Recommendation Report for Planning Permission for Works or Extension to a Dwelling

REF NO: R/281/21/HH

LOCATION: 15 Ruston Park
Rustington
BN16 2AB

PROPOSAL: Alterations to existing dormer and garage including extension to front of garage.

21/4851/4

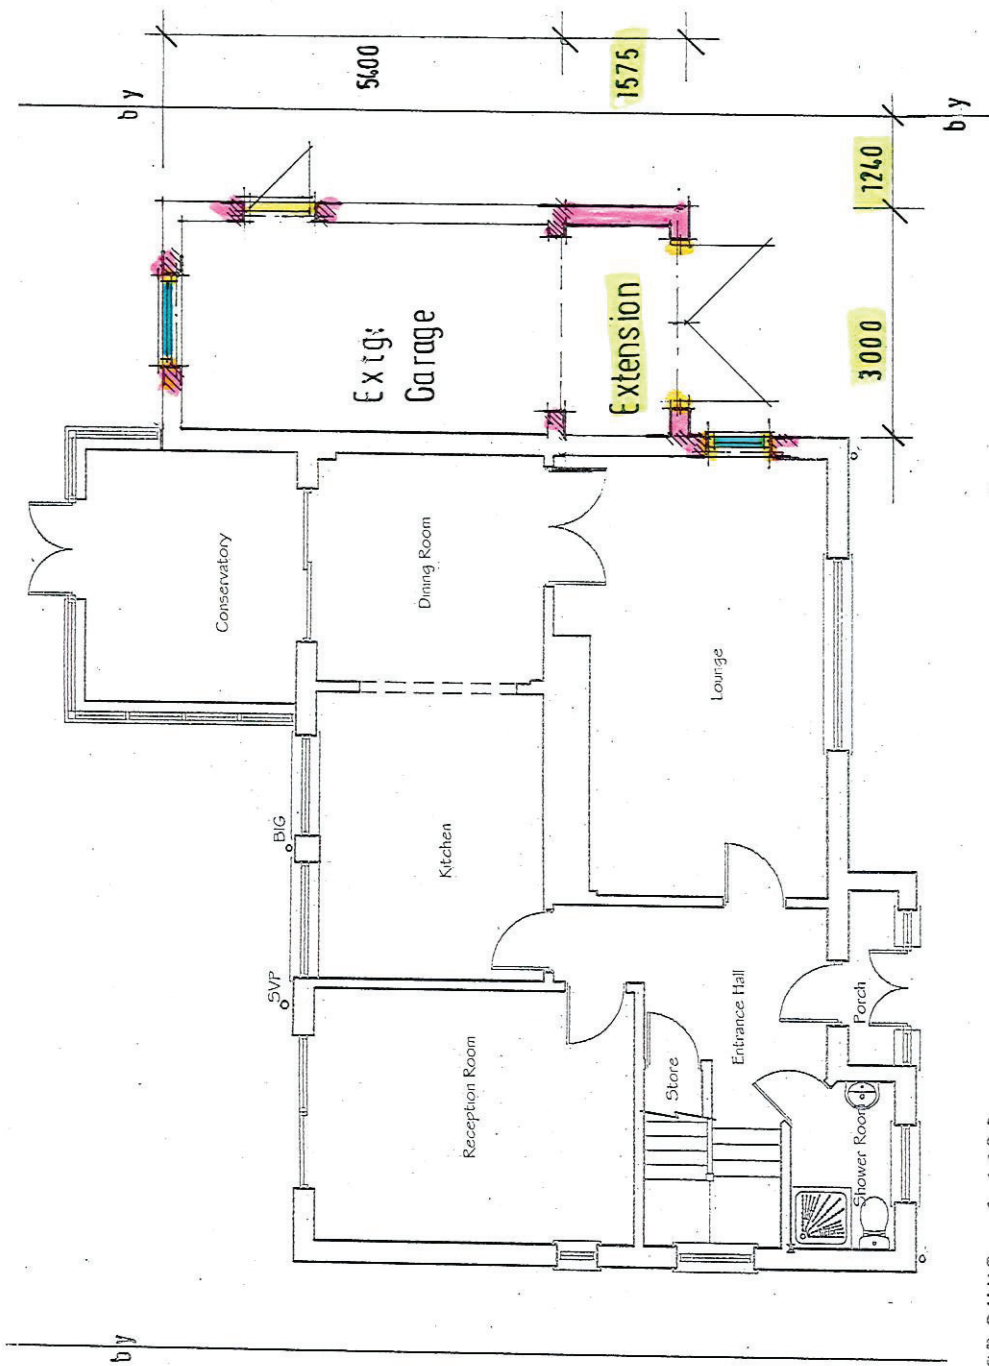
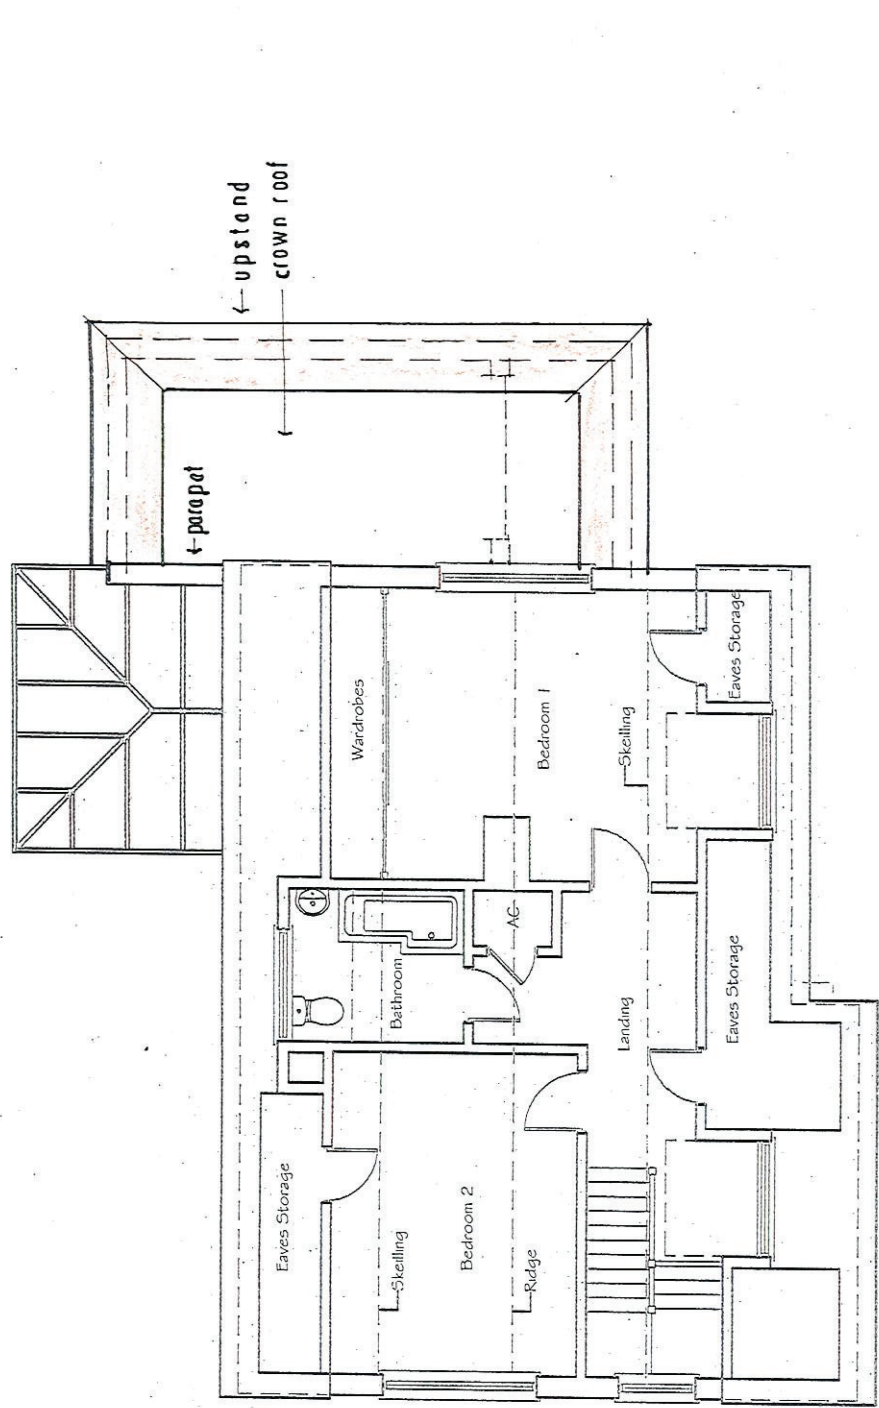
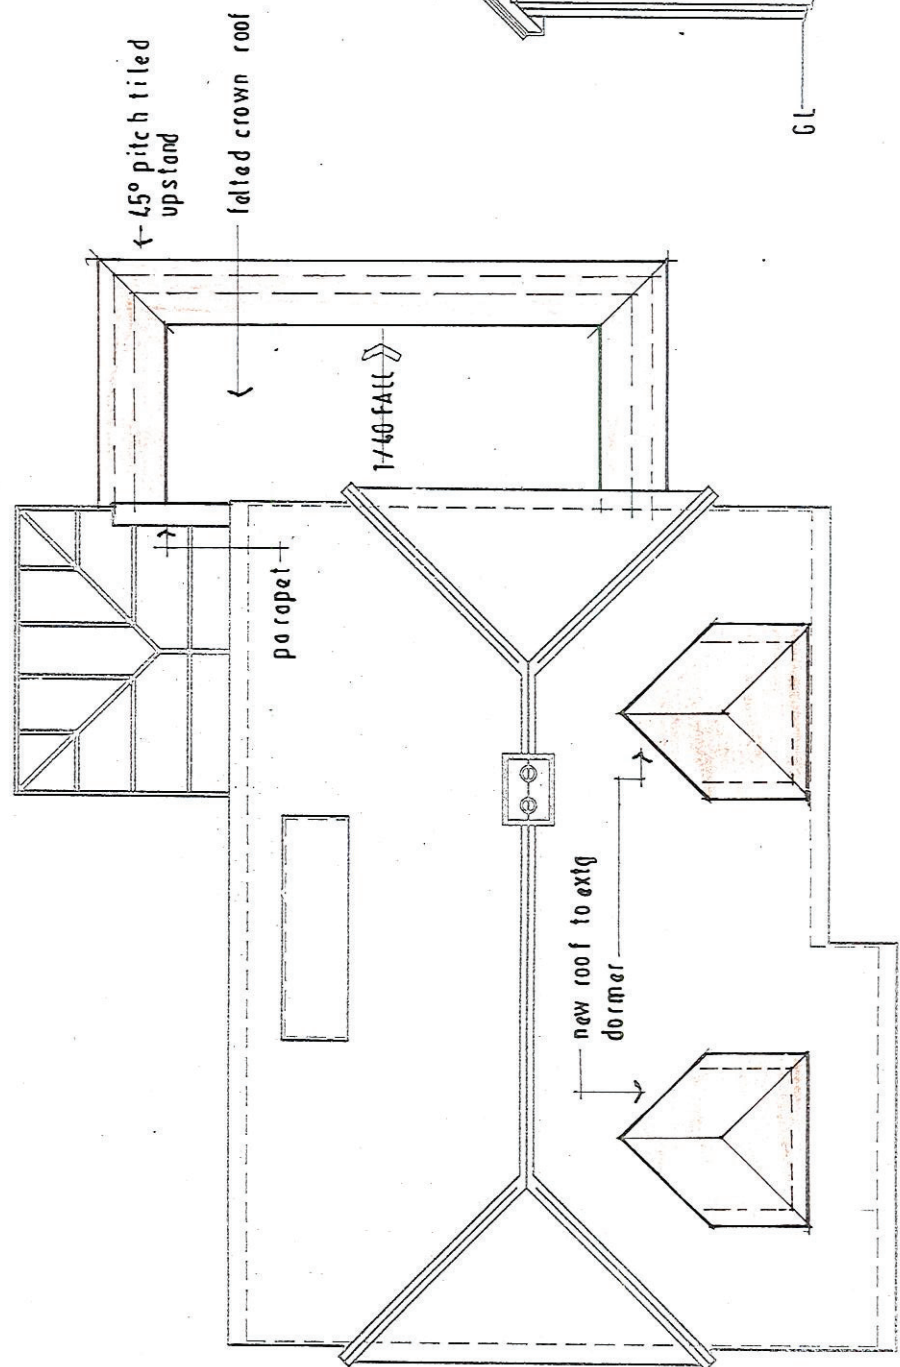
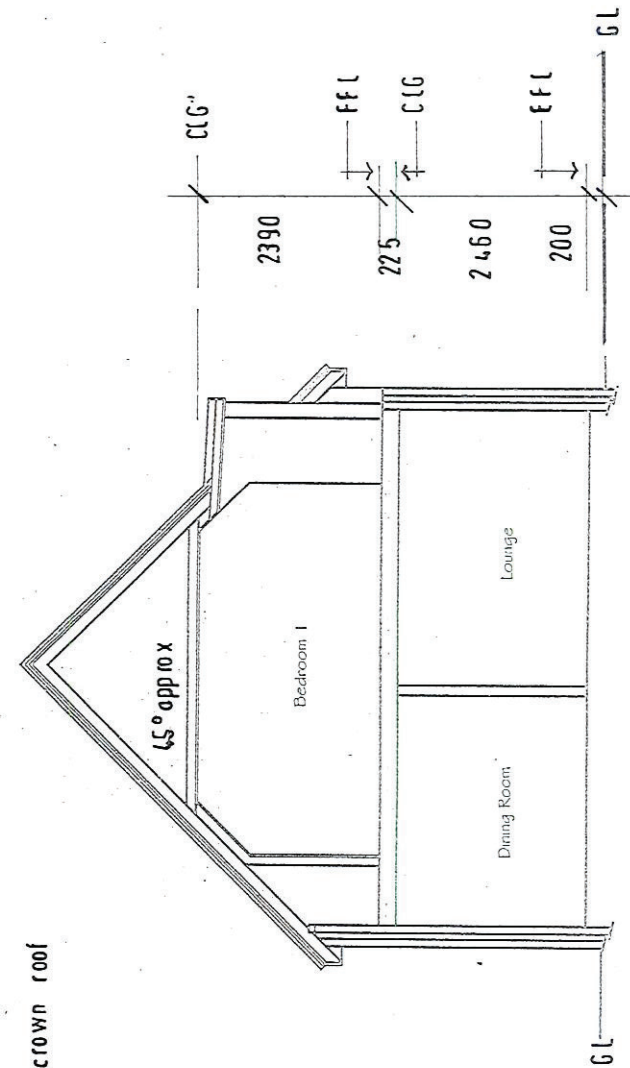
The extension is located to the side of the existing dwelling and will extend to the front of the garage. It is single storey, with a pitched crown roof at a height of 3.18m. The new roof will add an extra 0.58m to the height of the existing, but is not considered to result in unacceptable overbearing or overshadowing of neighbouring properties. The proposal retains a distance of 1.24m from the southern side boundary and complies with D DM4 of the Arun Local Plan.

Drawing No.: 21/4851/5

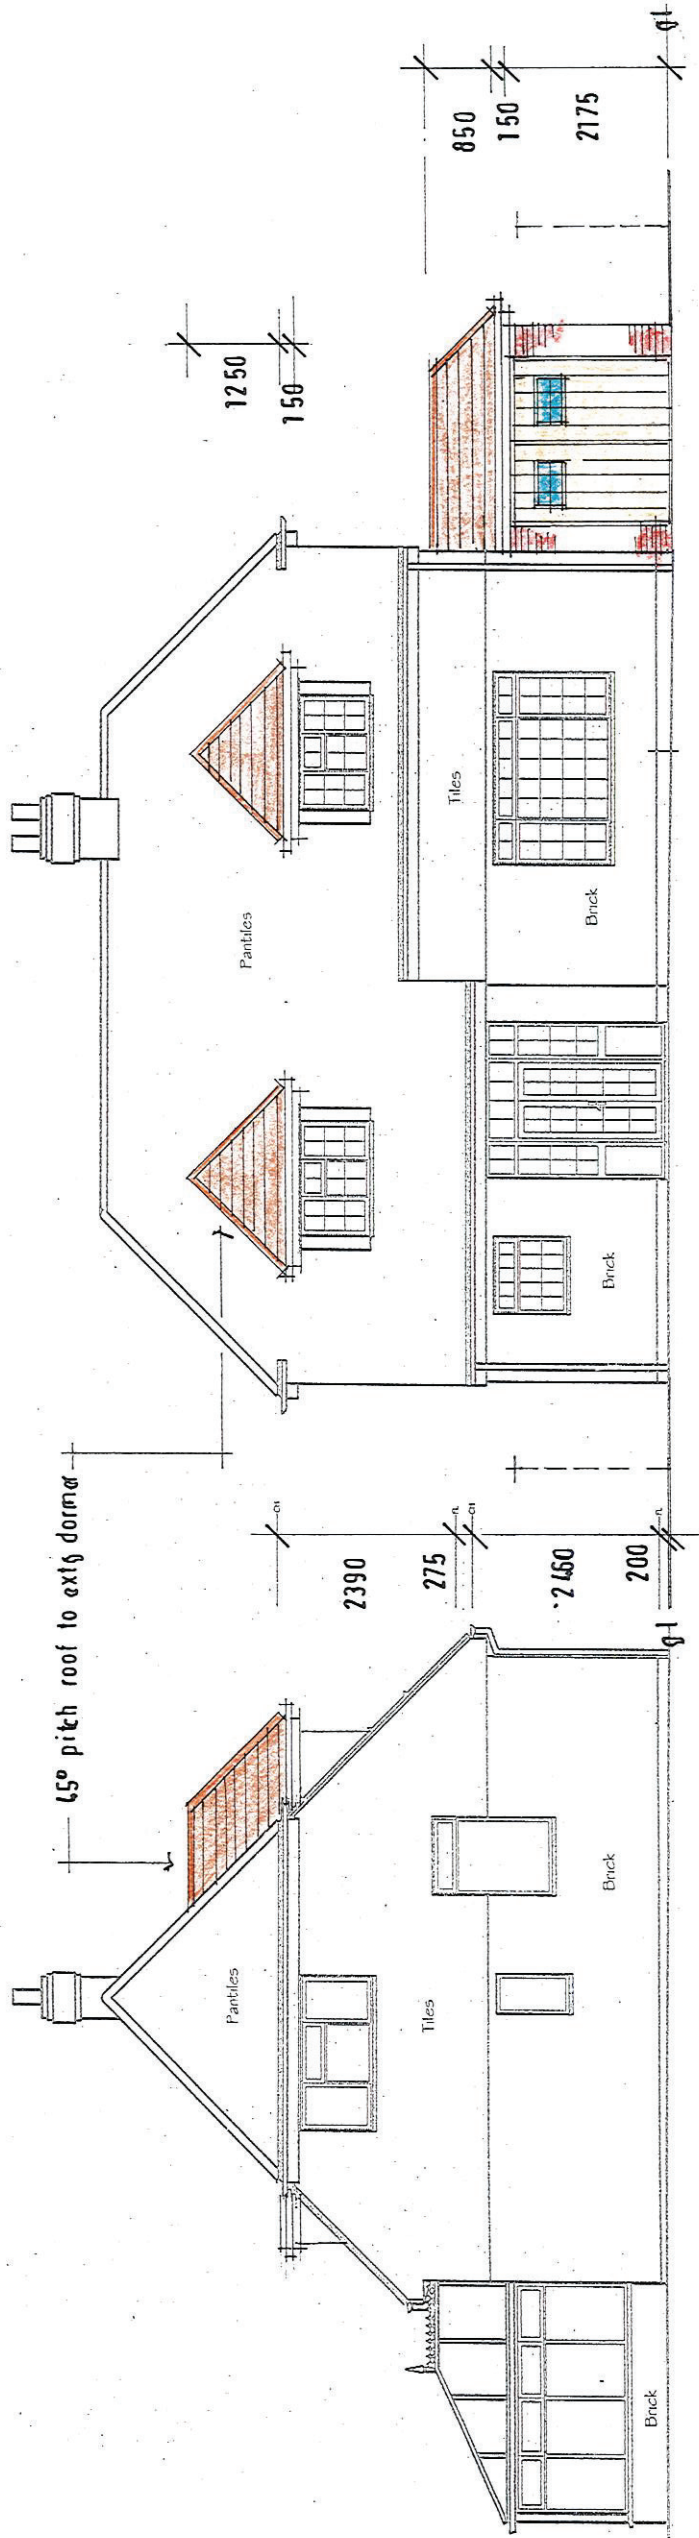
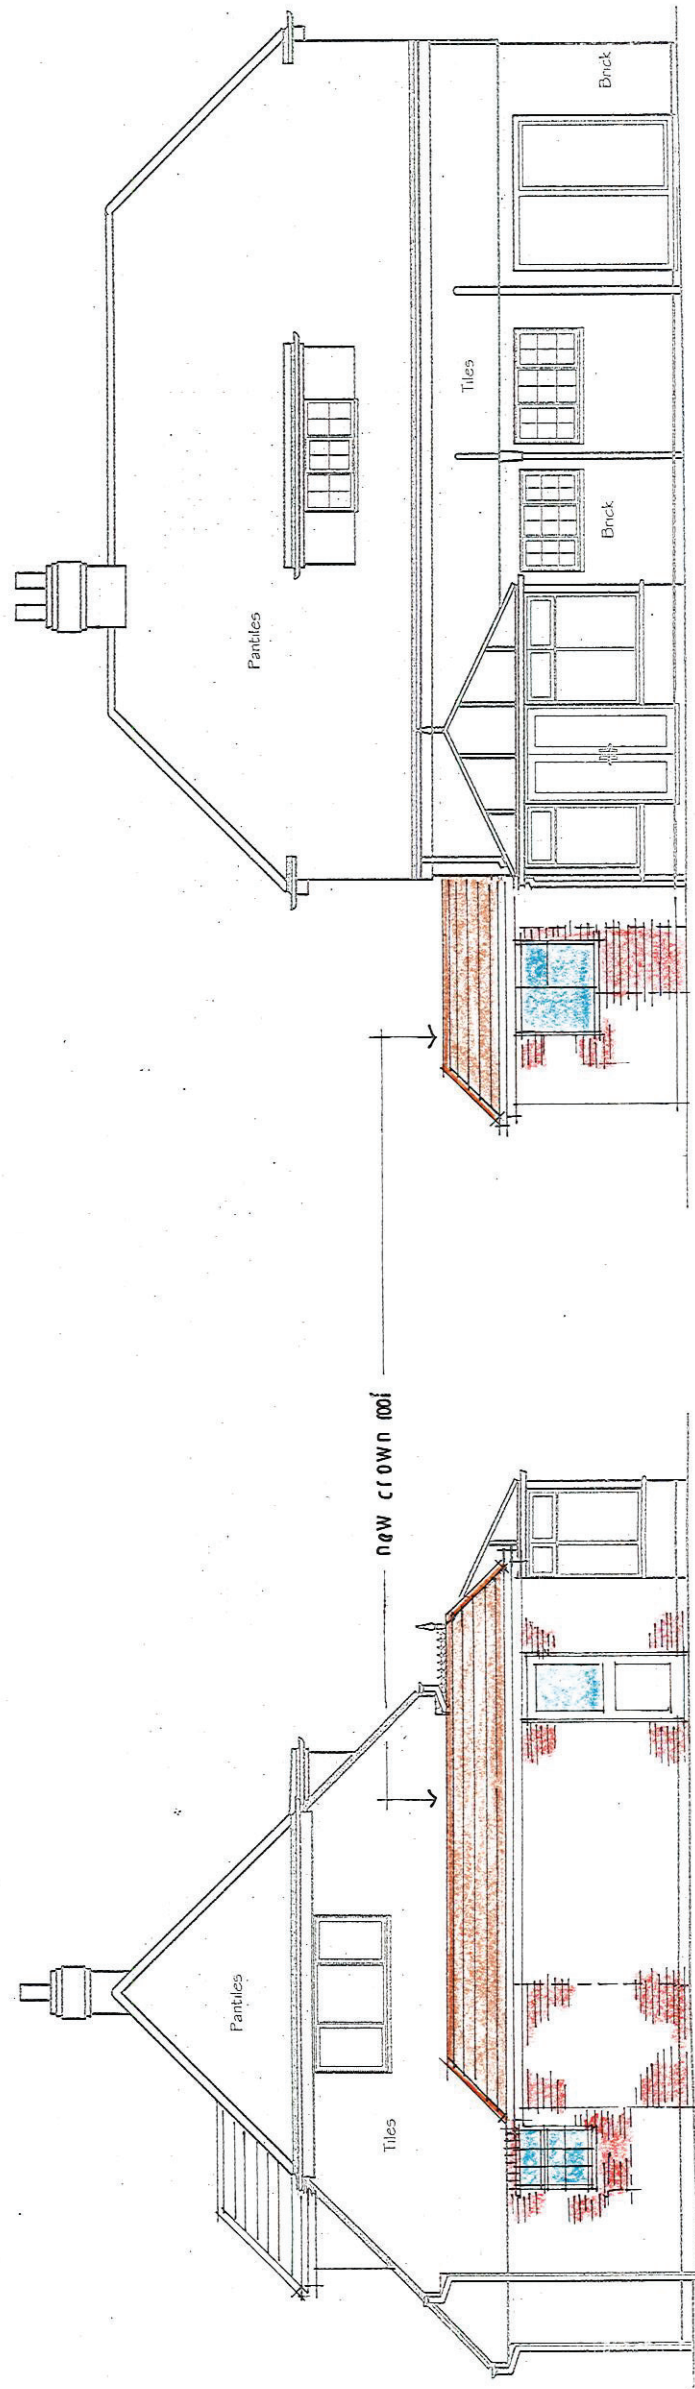
At present, the two dormers to the front elevation exhibit flat roofs, and will be altered by the proposal with the addition of two pitched roofs. The proposed roofs will have a height of 1.25m and be at an angle of 65 degrees, matching closely the angle of the existing roof. The garage extension will have a width of 3m and depth of 1.575m, extending to the front of the existing. It will have a pitched crown roof at an angle of 45 degrees, and will extend to and replace the whole flat roof of the garage. The pitched roof of both dormers and of the garage are considered to be more subservient to the roof design of the main dwelling than the existing flat roofs, and do not risk adverse harm upon the character or visual amenity of the property. The proposal will include a new garage door to the front of the extension, the installation of a door to the side of the garage and the replacement of a door with a window, to rear of the garage. These features have minimal impact upon visual amenity and are not considered harmful to the character or appearance of the property.

The garage extension retains 10.75m from the front boundary and will be visible from the street scene. It is, however, unable to be seen from the wider area, as visibility is blocked by the main dwelling from one side and reduced by the large hedges along the fence line from the other. The pitched roof dormers, being two storeys high, are clearly visible from the street scene, but given their close integration with the existing design, are not considered to be unduly out of character with the area or visually intrusive to the street scene.

The works appear subservient to the design of the dwelling and are well integrated. The materials will match the original building, ensuring minimal visual intrusion. The alterations to the dormers will alter the appearance of the front elevation, but will appear more integrated and less intrusive than the existing. The garage extension does not protrude past the building line of the front elevation or past that of neighbouring properties. The proposal as a whole poses little risk of disrupting the composition and rhythm of the street.

The extension and alterations to the garage include a new garage door to the front, a door to the side and new window to the rear, replacing an existing door. An existing window to the side of the main dwelling is blocked by the development and so will be replaced with a smaller window, of which poses no additional harm to residential amenity. The garage door features two small windows, but is not considered at risk of overlooking neighbouring properties, given its height and location. The door to the side will face the neighbouring boundary, but any potential risk of overlooking or harm to amenity is minimised by its scale, and the existing fence line that sits on the boundary, reducing the visibility between the two properties. The window to the rear does not directly overlook any neighbouring properties and does not give rise to any overlooking, overbearing or overshadowing.
